PROJECT: BOYLE RESIDENCE
DRAWING TITLE: MERCER ISLAND, WA
GENERAL NOTES

PERMIT SET

**BOYLE RESIDENCE
 MERCER ISLAND, WA
 FOUNDATION & FIRST FLOOR
 FRAMING PLANS**

PROJECT	BOYLE RESIDENCE
DRAWING TITLE	FOUNDATION & FIRST FLOOR FRAMING PLANS
DATE	07/25/17
REVISION	
SHEET NO.	S2.1

FOUNDATION PLAN

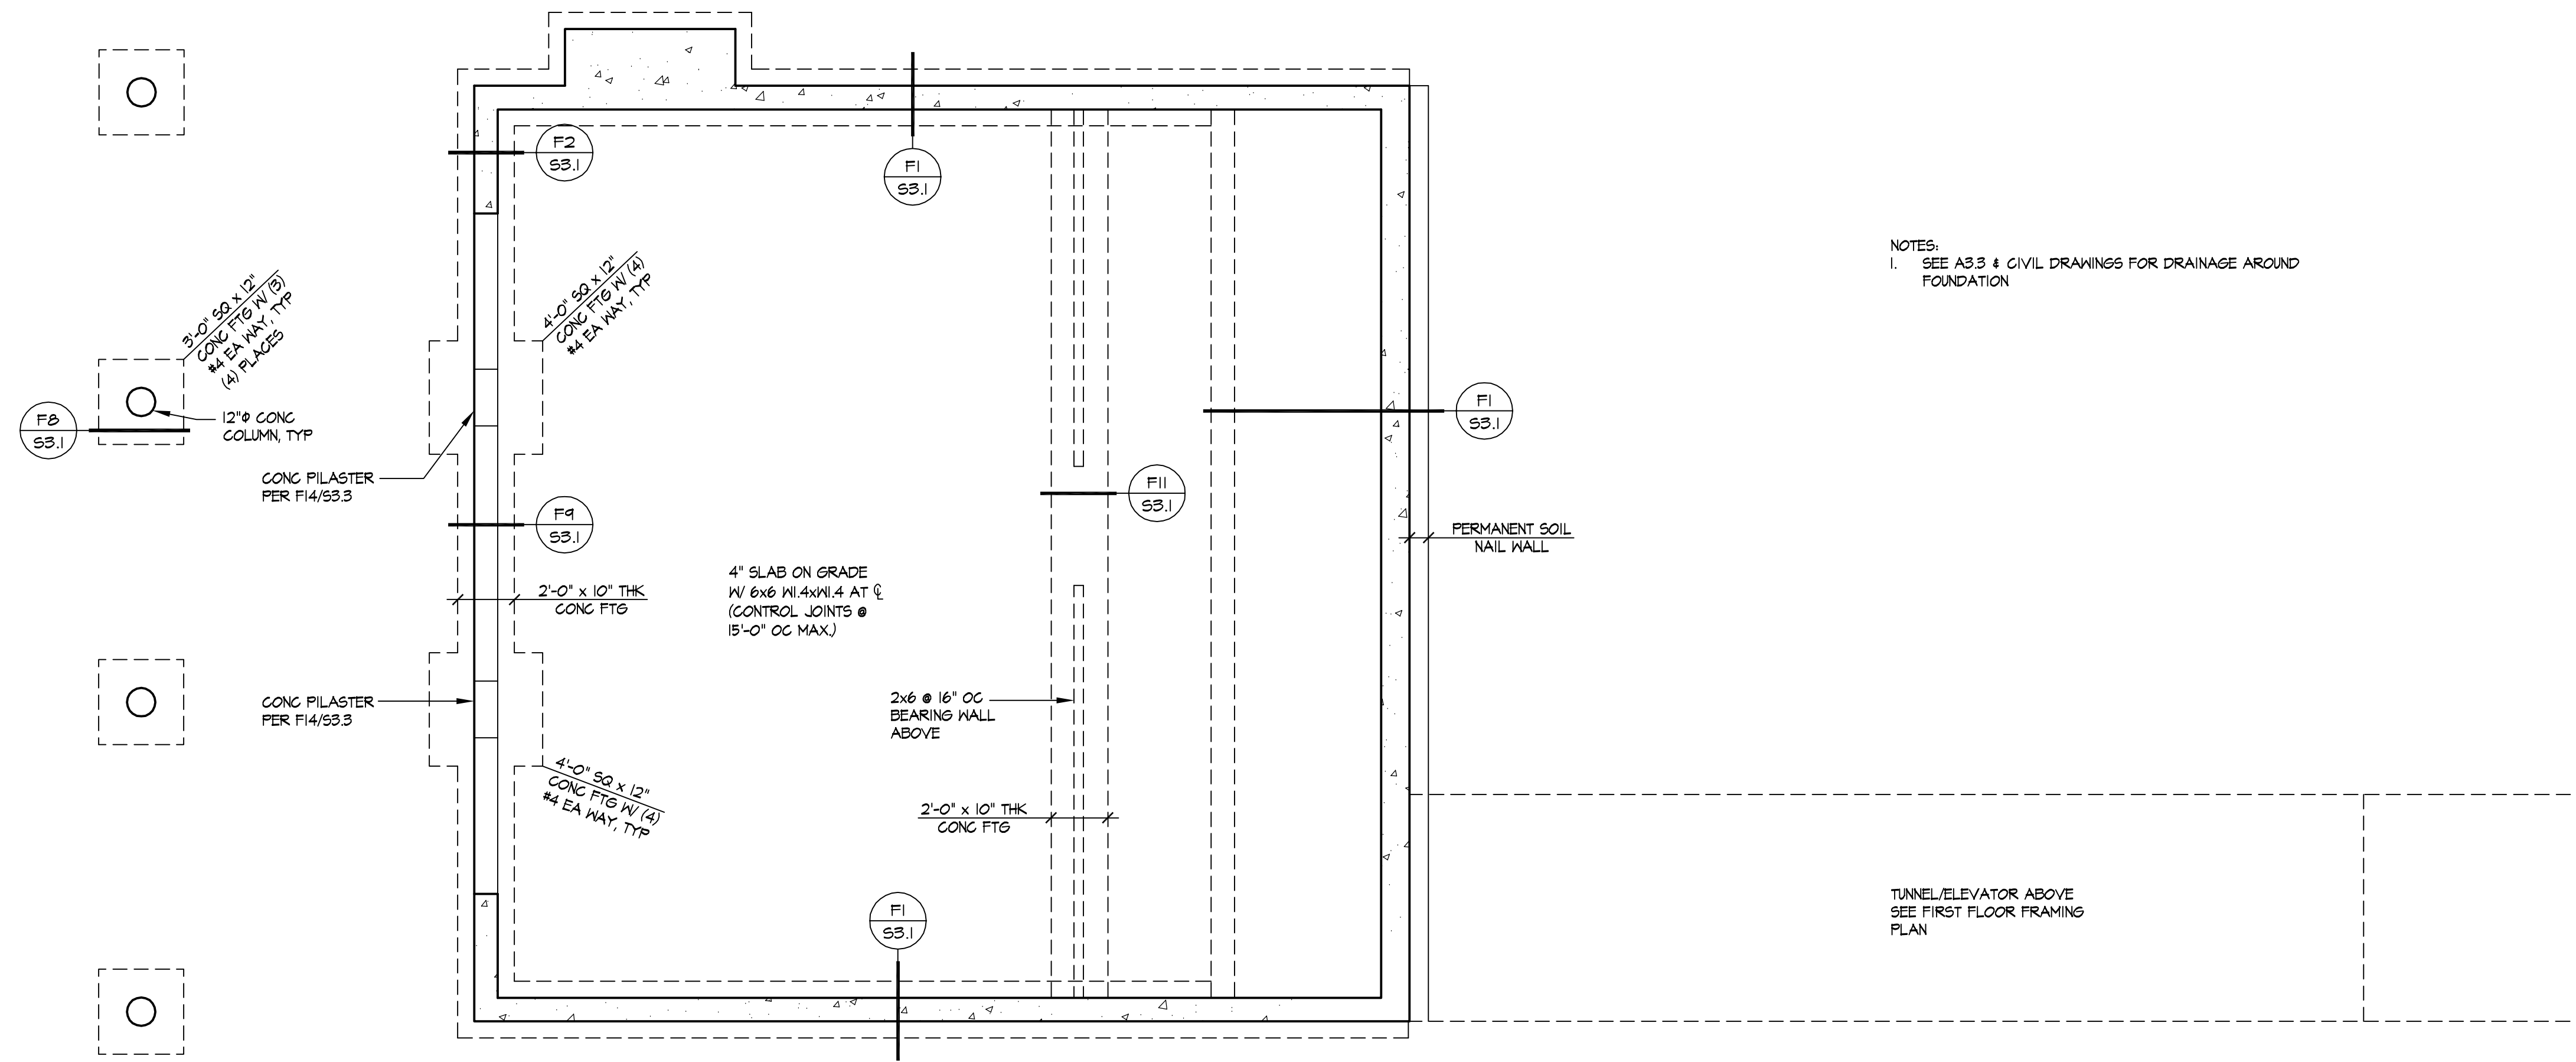
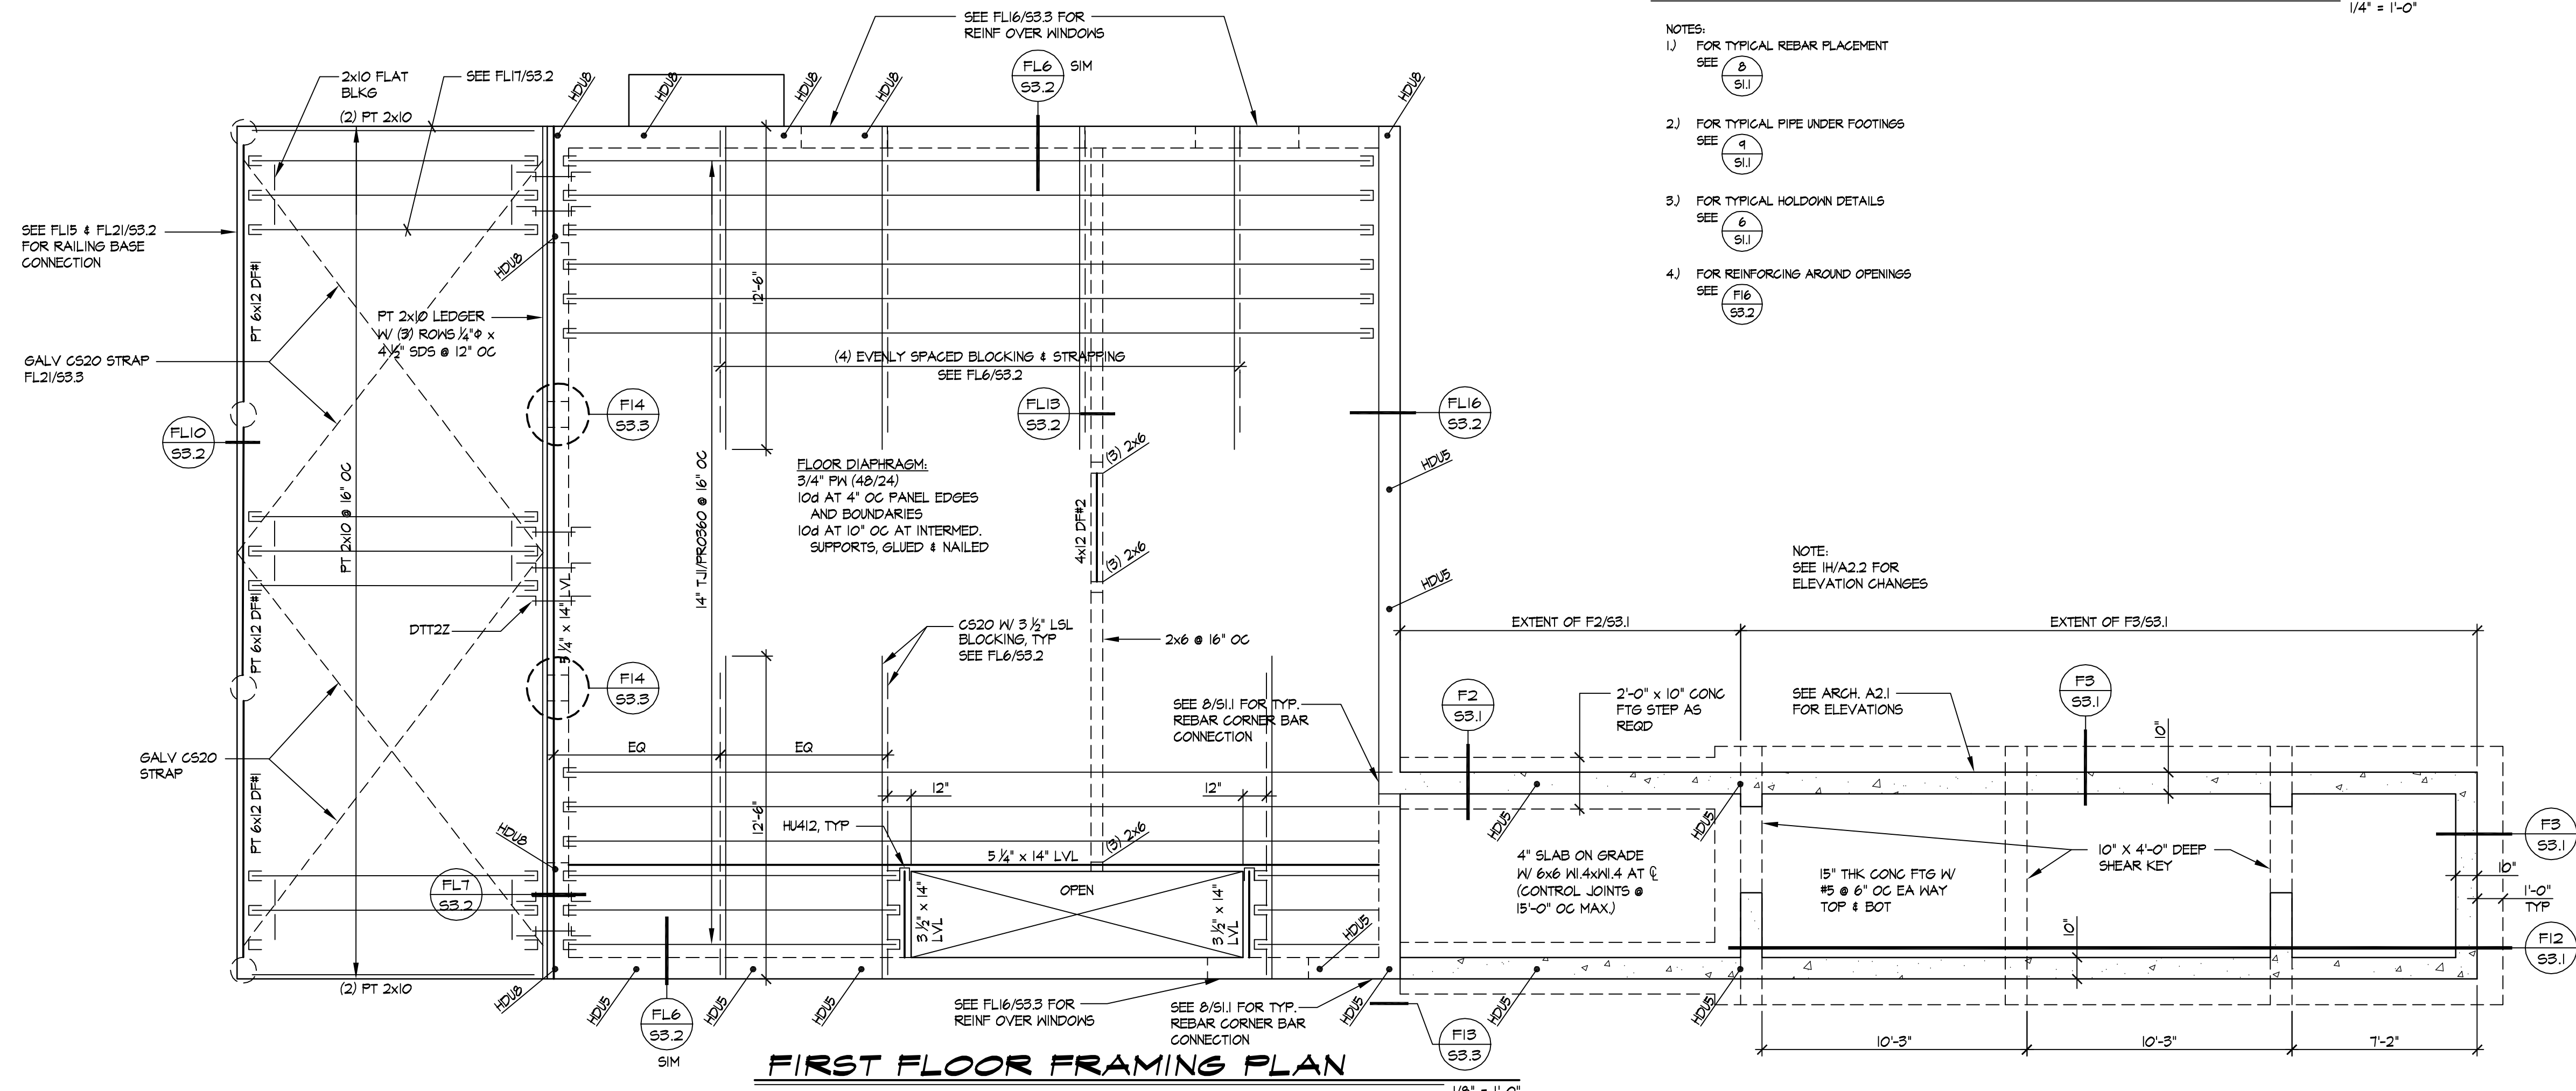
Building Review (paul.skidmore)
 Comment
 Provide calculations and detailing to provide out-of-plane support at top of concrete walls as required by ASCE 7-10

Building Review (paul.skidmore)
 Comment
 Include surcharge load from footing above in retaining wall design.

Building Review (paul.skidmore)
 Comment
 Provide.

Building Review (paul.skidmore@mercergov.org)
 Comment
 Shoring cannot be a deferred submittal. Please provide calculations, design, shoring plans, shoring elevations, tieback locations and extents, shoring details, and other information as necessary to fully describe construction.

Building Review (paul.skidmore@mercergov.org)
 Comment
 Provide detail or otherwise indicate construction where foundation and footing abuts. Step footing to lower level or include surcharge in retaining wall design as well as backfill with structural fill per geotech.

Building Review (paul.skidmore)
 Comment
 Indicate framing and construction for spiral stair. Provide bearing for stair.

Building Review (paul.skidmore)
 Comment
 Provide accurate detail this location.

Building Review (paul.skidmore)
 Comment
 Is this really "SIM"?

Building Review (paul.skidmore@mercergov.org)
 Comment #1
 Provide detail showing how portions of structure are "interconnected" as required by ASCE Section 12.1.3. Provide appropriate attachment between separate wings as required. Alternatively, provide appropriate separation joint between building portions as required by ASCE Section 12.12.3.

Building Review (paul.skidmore)
 Comment
 Provide accurate detail this location. Architectural drawings indicate concrete extends beyond the first floor elevation.

Building Review (paul.skidmore)
 Comment
 Call out slab-on-grade construction this area

Building Review (paul.skidmore)
 Comment
 Indicate top wall and bottom of footing elevations (typical). Locate step locations on plans.
